## Waste Management Facility, Botany

Integrated Water Management Strategy

**Coombes Property Group Pty Ltd**

A response to this submission was provided by Bayside Council (their ref: SSD-2024/10) dated 09/09/2024 – and the response to their civil engineering queries is summarised below (note flood and landscape related queries are responded to in other respective reports):

Figure 5. MUSIC Model Treatment Train and Results

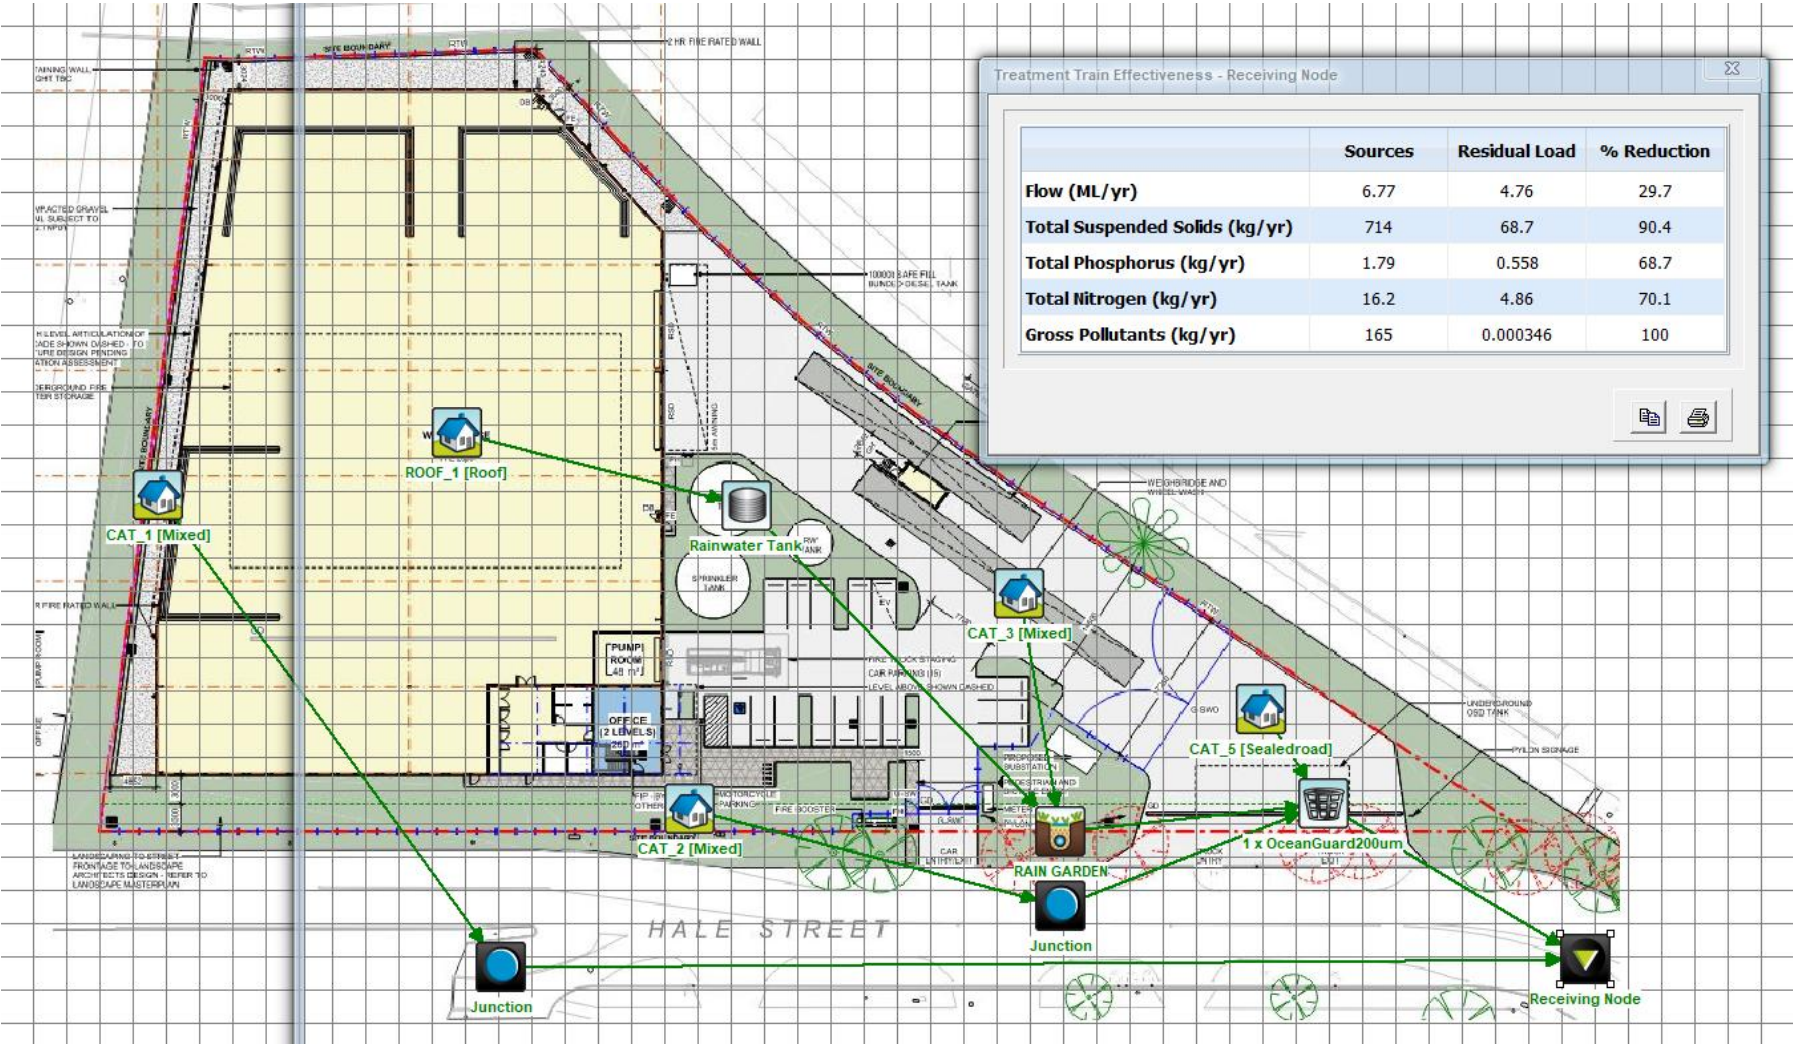
<p>Furthermore, figure 5 of this report cannot be assessed as it does not include the areas of each catchment and is not supplemented by stormwater plans verifying the catchment areas and demonstrating the treatment train is feasible.</p>	<p>Refer to Table 4 on Section 5.8 and Catchment area plan in Appendix C</p>	<p>Section 5.8: Table 3; Appendix C</p>
<p>The parameters of the bioretention system in the MUSIC model shall be shown. The bioretention system appears to be overperforming and it’s not clear how the site will effectively capture gross pollutants from impervious areas. Furthermore, it needs to be detailed how this system will work given the substation and trees proposed in this area.</p>	<p>This is included in the soft copy of the MUSIC file provided for council review.</p>	<p>Attached .sqz file</p>
<p>A soft copy of the amended MUSIC modelling shall be provided.</p>	<p>As above</p>	<p>Attached .sqz file</p>

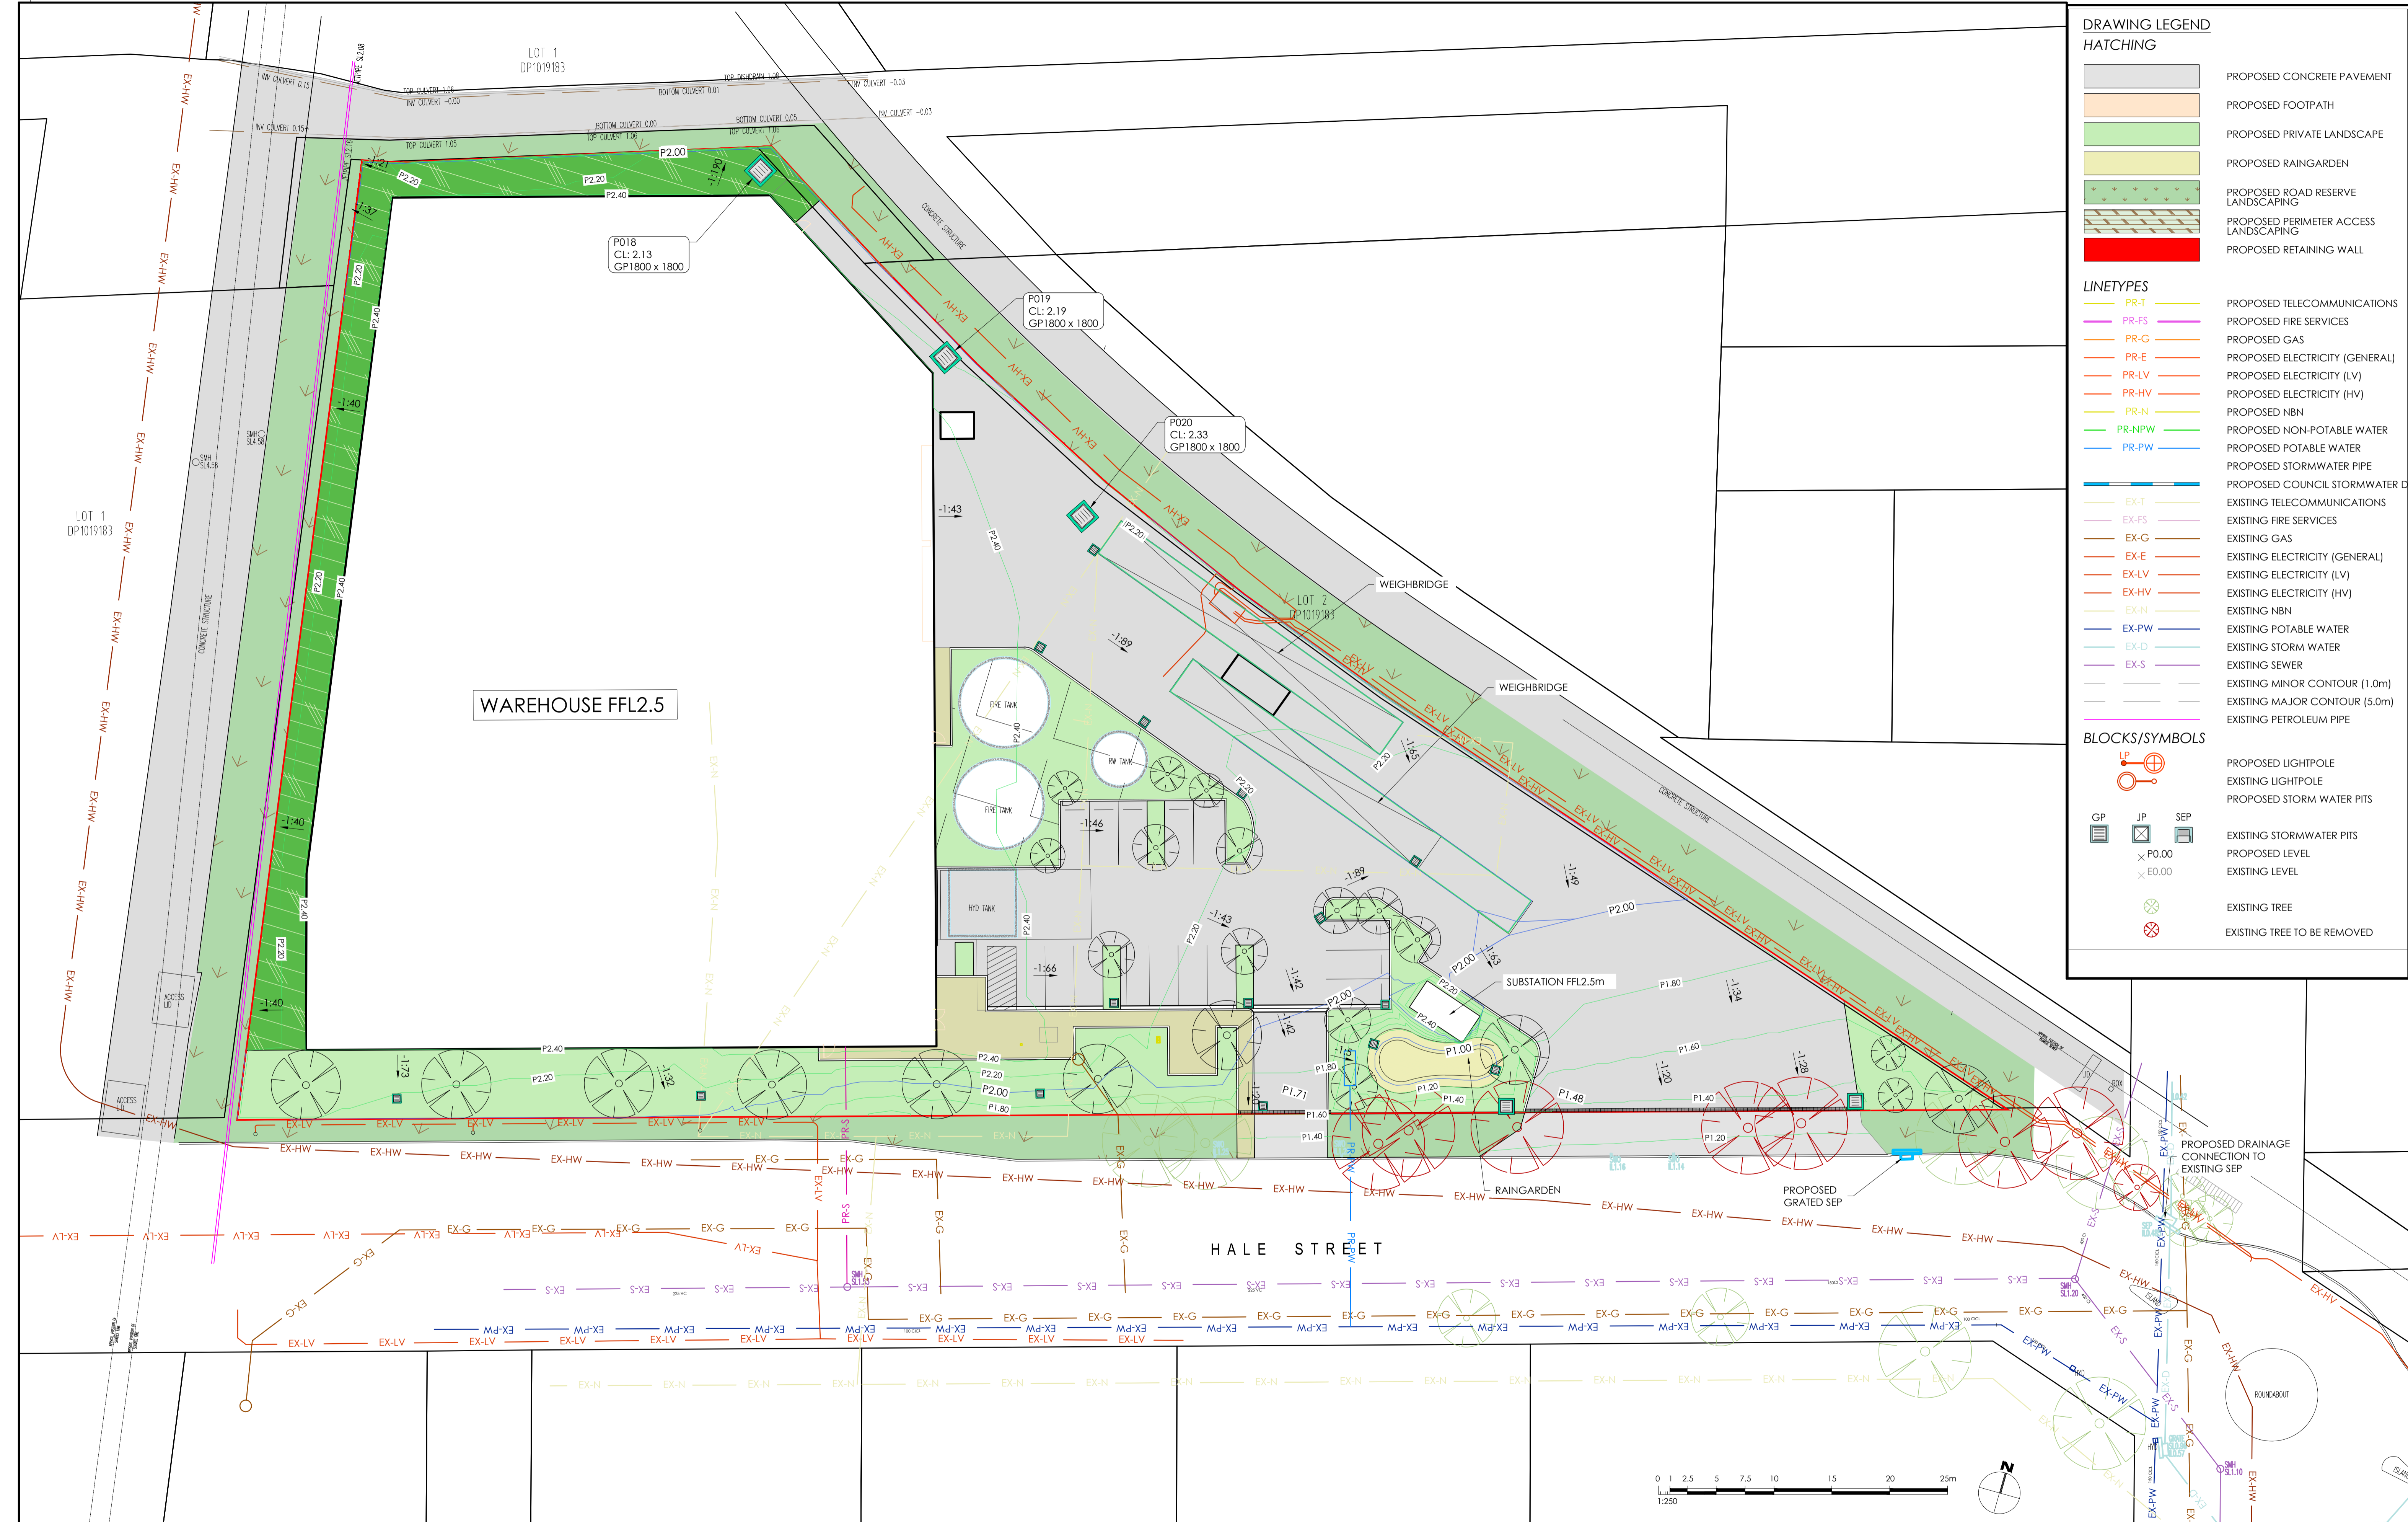
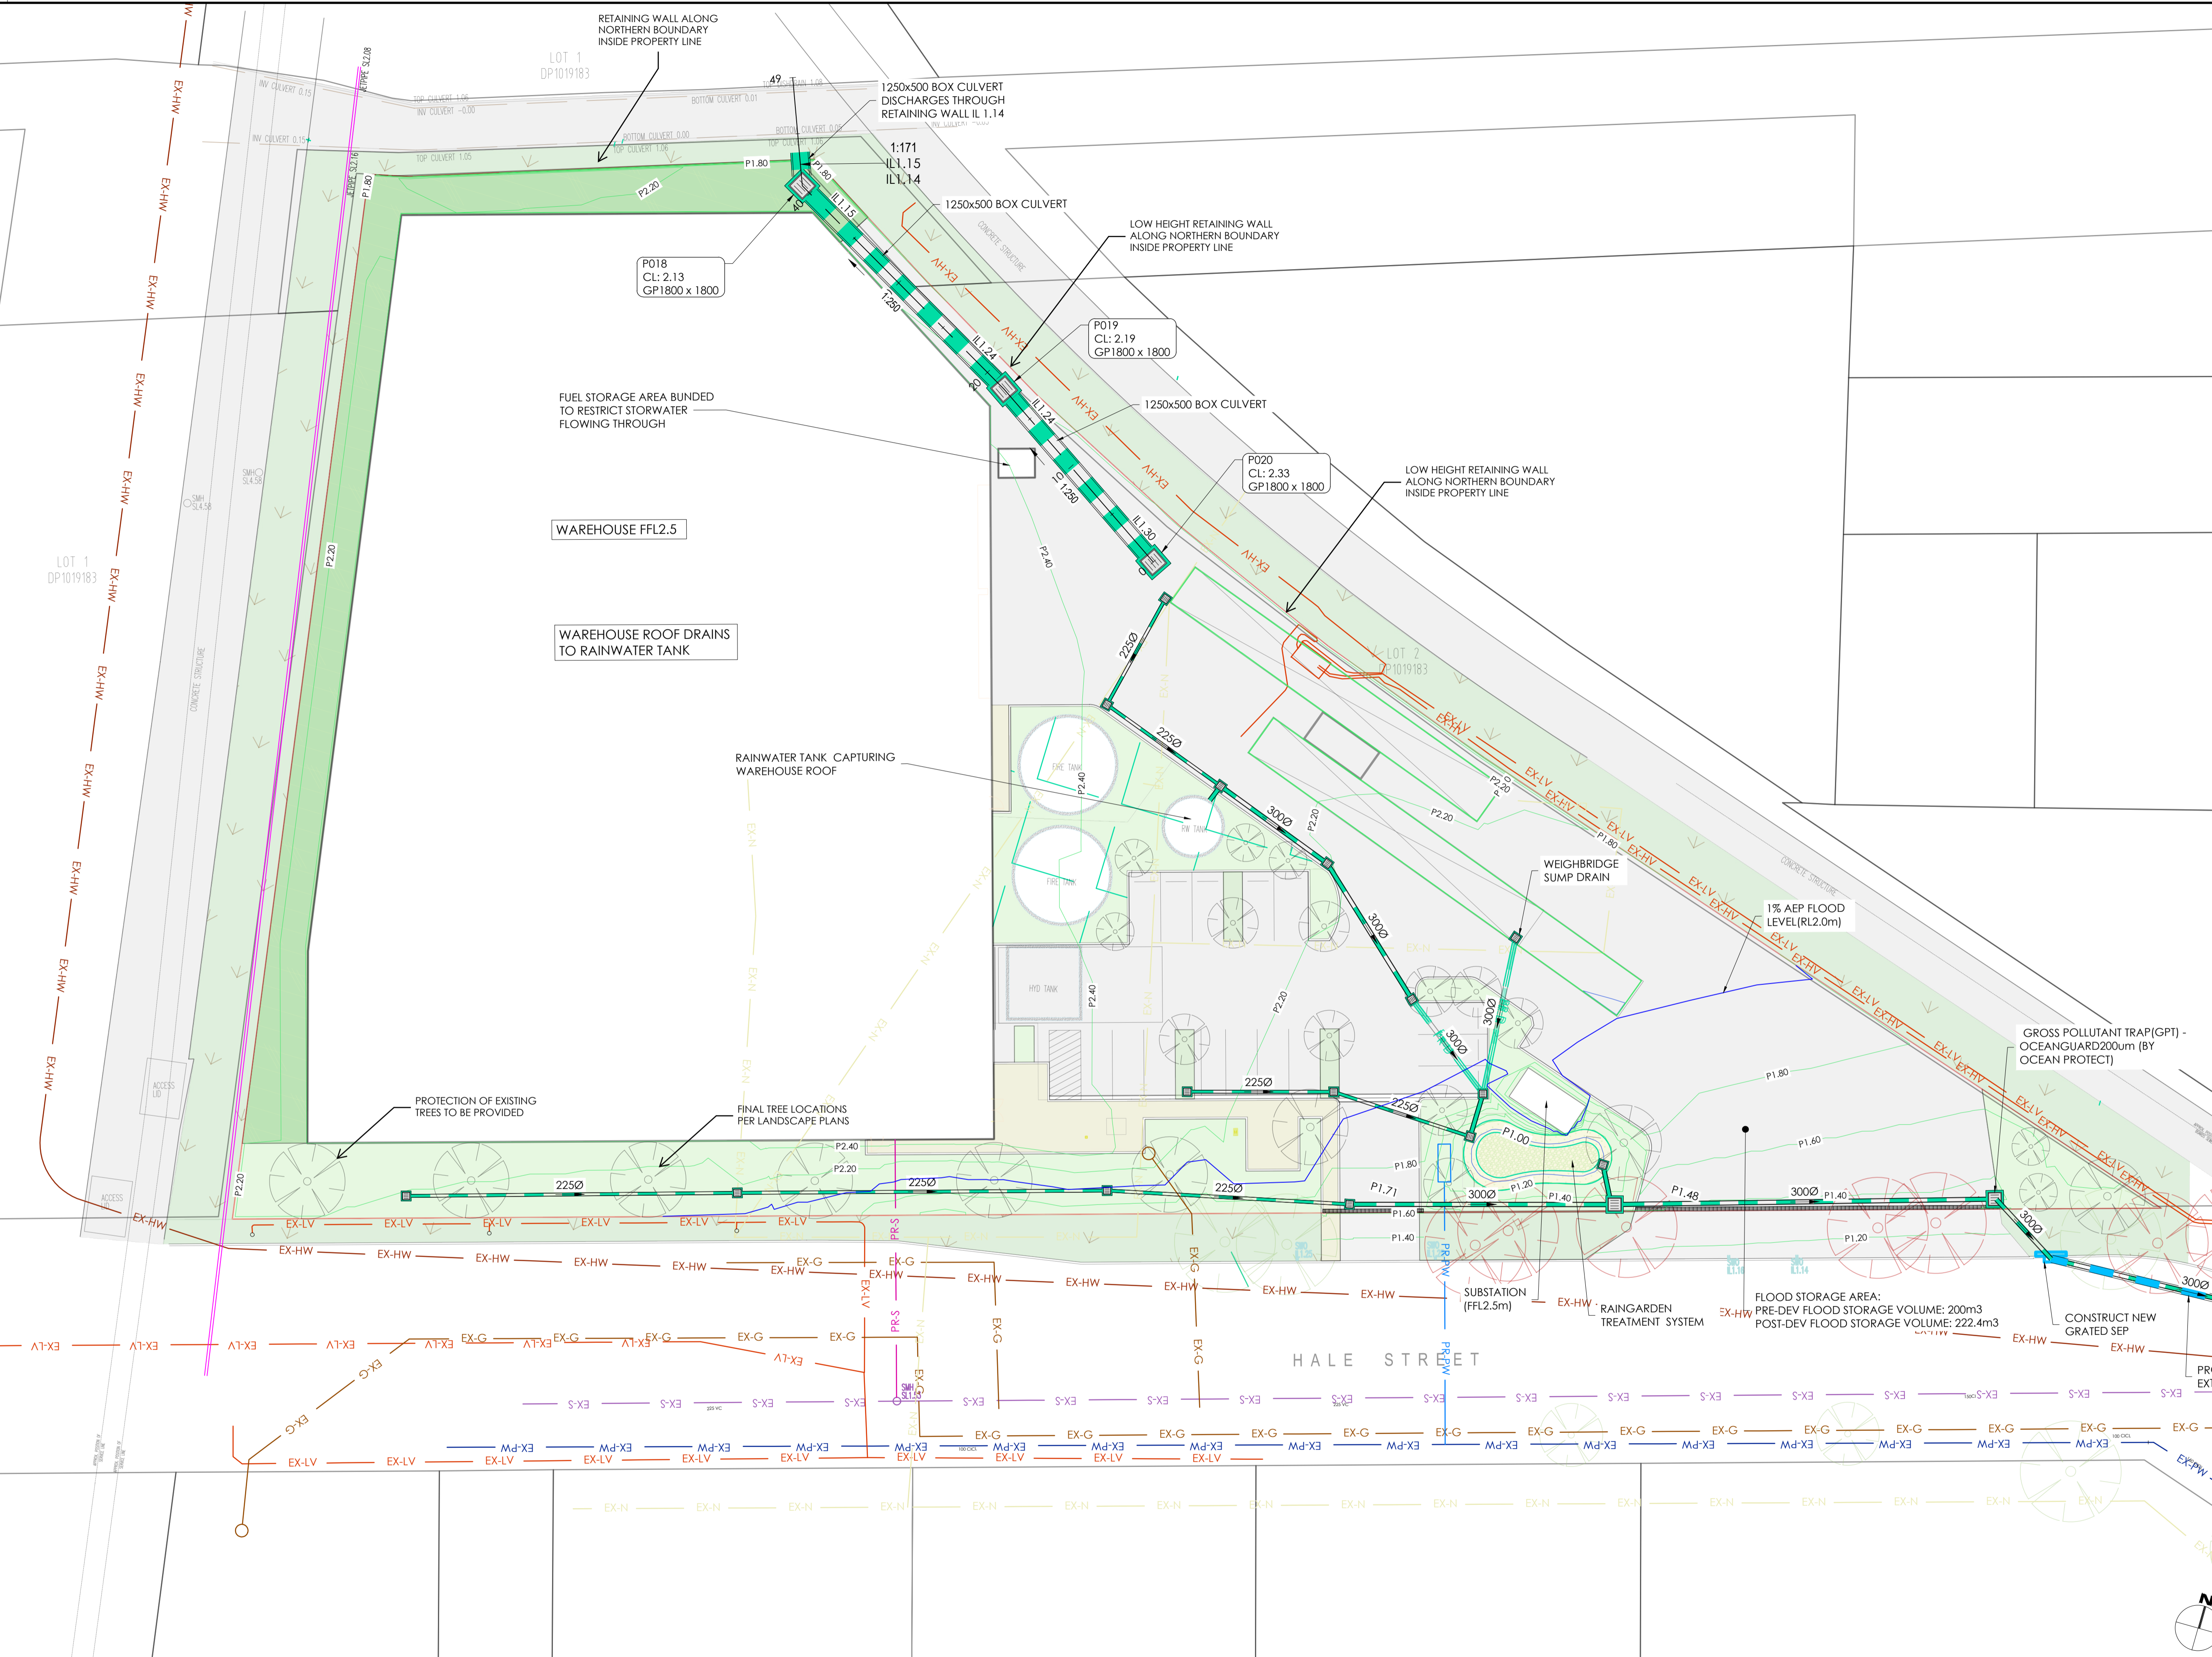
<p>The substation is to be flood proofed to the 1% AEP + 500mm level.</p>	<p>Noted. The electrical substation floor level is set at 2.5m which is above 1% AEP + 500mm freeboard.</p>	<p>Appendix B shows the proposed level of the substation.</p>
<p>A set of stormwater plans prepared by a suitably qualified civil engineer were not provided. As a result, the development cannot be assessed to determine if it satisfies clause 6.3 and clause 5.21 of the Bayside LEP and the requirements of the Bayside DCP (section 3.9, 3.10 and 9.5). These plans need to be provided to enable the development to be fully assessed.</p>	<p>We have included a revised and more detailed concept in Appendix B for reference. The provision of a full set of detailed design plans is not typical at this stage of a development application as it will be undertaken at Construction Certificate stage, however the information now included in Appendix B should provide enough detail to facilitate review</p>	<p>Appendix B</p>

Bayside Council Comments	Proponent Response	Location Addressed
<p>The stormwater plans shall include the following details at minimum:</p> <ul style="list-style-type: none"> <li>• Site layout;</li> <li>• Surface and roof drainage plans;</li> <li>• Existing site contours and final design levels;</li> <li>• WSUD catchment plan;</li> <li>• Finished floor levels and footprints of the proposed development/ structures;</li> <li>• Location and size of the internal and external drainage systems, rainwater re-use system, flood storage tank systems;</li> <li>• Levels and location of discharge points for the stormwater system including design details of the Hale Street drainage extension;</li> <li>• Cross-sections details of the rainwater tanks and flood storage tank;</li> <li>• Maximum water surface levels in each storage;</li> <li>• Details of surcharge/overflow paths for the major storm;</li> <li>• Location and manufacturer spaces of stormwater quality improvement devices; and</li> <li>• Flood storage tank base plan is to be provided, showing all base levels and minimum 1% fall towards the outlet pipe;</li> <li>• A lid plan is to be submitted for the flood storage tank; showing the distance from pit centre to centre. The grates spacing of the access grates to be as per Section 6.6.2 of Bayside Technical Specification Stormwater Management.</li> <li>• Full details of the bioretention system including manufacturers details.</li> <li>• Construction and operational phase sediment and erosion control plan.</li> </ul>	<p>As noted above we have provided a more detailed concept plan that indicates the majority of this information – that we believe is appropriate at this stage of the development process.</p> <p>The degree of detail requested here is achievable in the detail design phase of the project.</p>	<p>Appendix B</p>
